GOVERNMENT ARCHITECT NEW SOUTH WALES

20 February 2026

PROJECT: 10 Dangar Street, Wickham
RE: State Design Review Panel – 11 February 2026 – Review 2

Level 06

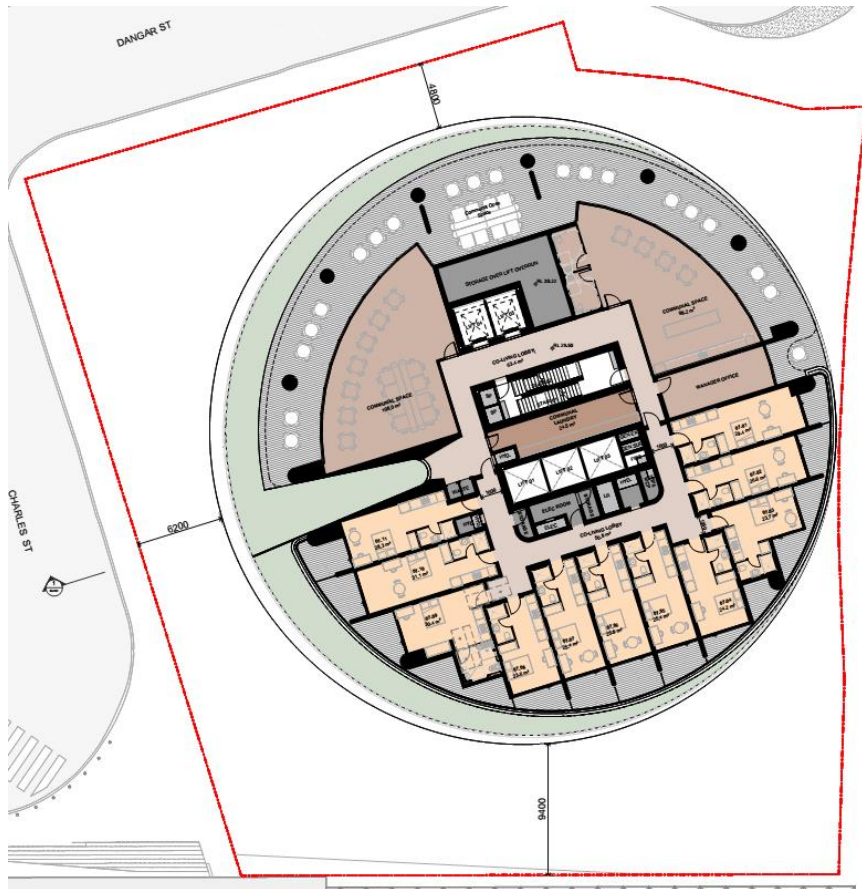
18. Reassess distribution of communal open space across the tower, including opportunities for smaller, vertically distributed spaces at upper levels.
19. Review Level 6 communal open space to ensure there is adequate solar access, amenity and capacity to cater for the proposed density. Further test opportunities to distribute communal open space in the upper levels.

# Ground Floor & Public Domain Plan

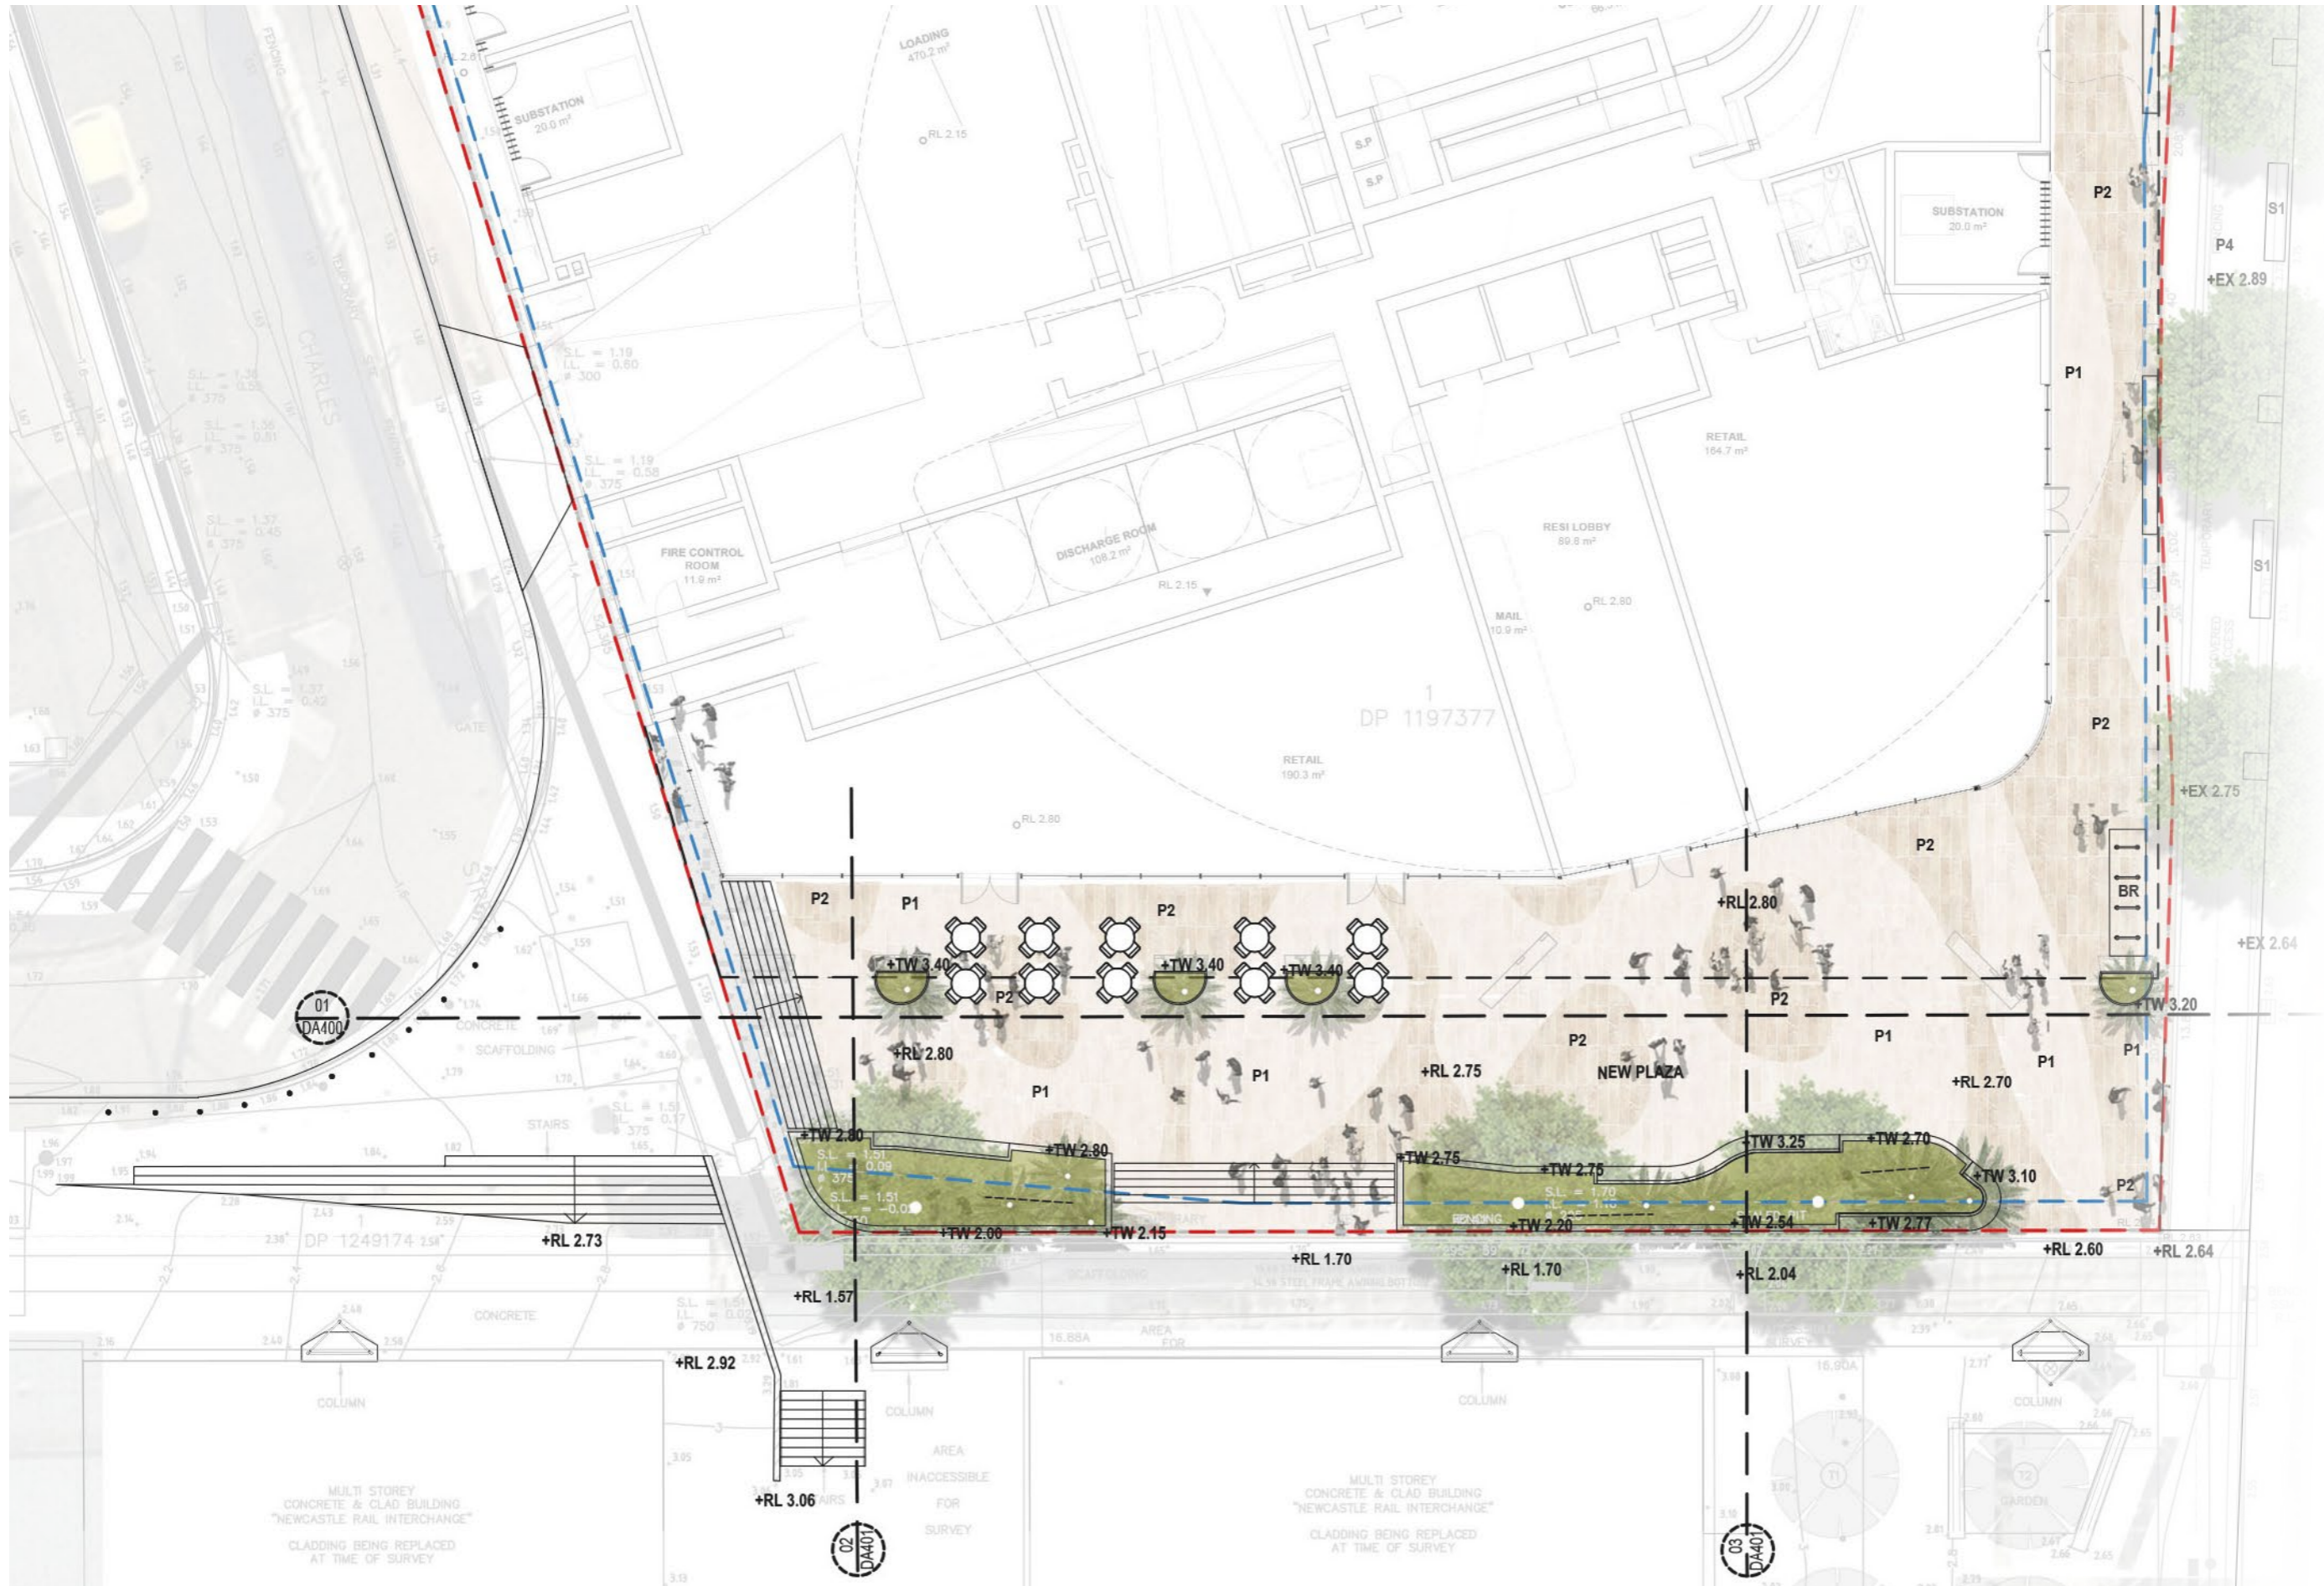
- a. Provide movement analysis identifying key desire lines and anticipated volumes.
 - b. Clarify how the south-east corner resolves pedestrian rounding and crossing movement.

- c. Clearly demonstrate how the relocated east-west cycle route functions and seamlessly connects to Hannell Street and the wider network.
2. Increase the width and depth of the colonnade, particularly along Hannell Street, to better respond to the scale of the building and anticipated foot traffic. This could include reducing the retail area to achieve a more generous and functional colonnade.

3. Revisit the angle and configuration of the stairs on the southwest corner and demonstrate how the level changes are addressed.
4. Continue to refine the configuration of the through-site link to improve usability and spatial quality, having regard to the expected volume of pedestrian movement.

- a. Review column placement, including the potential to cantilever the single column at the south-east corner.
 - b. Demonstrate that the configuration of columns, landscape and outdoor seating maintains adequate clearances and supports clear pedestrian movement within the through-site link.

- c. Reconsider the configuration and alignment of the stairs to ensure a more intuitive transition.
5. Review the distribution of ground floor uses to increase spatial clarity and avoid fragmentation of the ground plane, including redistributing some of the programming to floors above and/or below.

6. Revisit the blank facade and servicing dominance along Charles Street and Dangar Street and investigate opportunities for activation. For example, consider introducing a café or public artwork in collaboration with the local Aboriginal community.

7. The water feature proposed sits outside the site boundary. Liaise with Council to prioritise the amenity for all public domain works outside the site boundary.
8. Provide sections illustrating how the development interfaces with the transport interchange to the south and adjacent development, including Honeysuckle HQ to the east beyond Hannell Street, to demonstrate cumulative built form impacts, scale relationships and pedestrian movement.
